DELEGATED DETAILS DECISION

Report of the Head of Planning, Building Control, Sport & Green Spaces

Address 37 ST JOHN'S ROAD UXBRIDGE

Development: Details pursuant to conditions 3 (Materials), 16 (Landscape Scheme) and 20 (Footpath) of planning permission Ref: 15811/APP/2014/2444 dated 6/02/2014 (4 x 2-storey, 3-bed, semi-detached houses with habitable roofspace and 3 x two storey, 3-bed, detached houses with habitable roofspace with associated parking and amenity space involving demolition of existing B1 office building)

West Elevation
House type 1

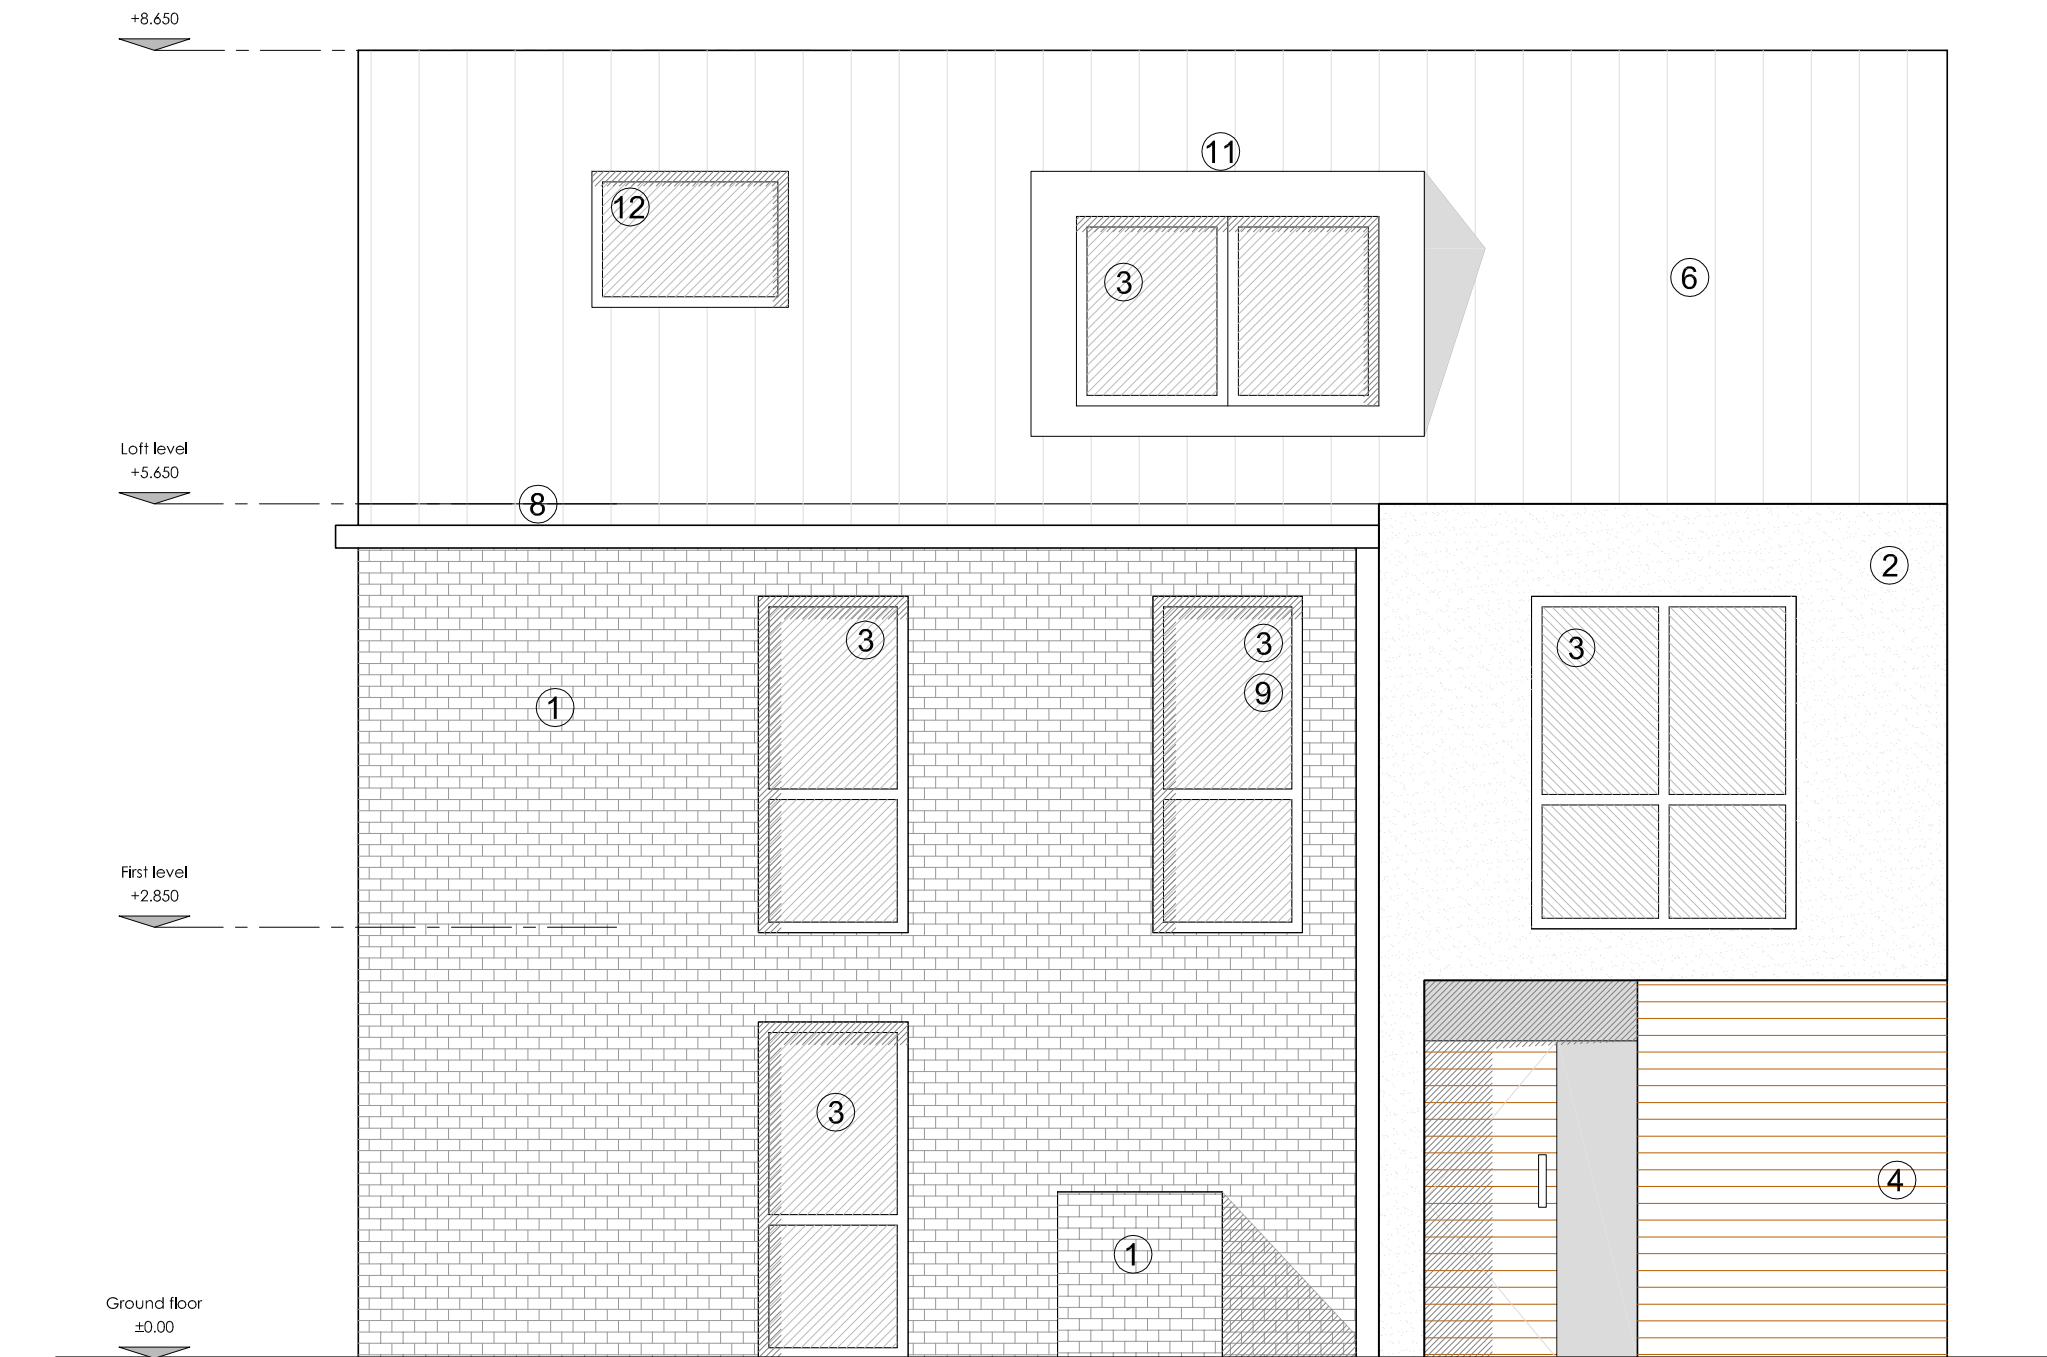
Condition 3 - The plans and photographic samples submitted in relation to the proposed materials to be used at the site are considered to have an acceptable impact to the visual amenity of the surrounding area and therefore meet the requirements of the condition. The materials are listed in plan ref 740-150/A.
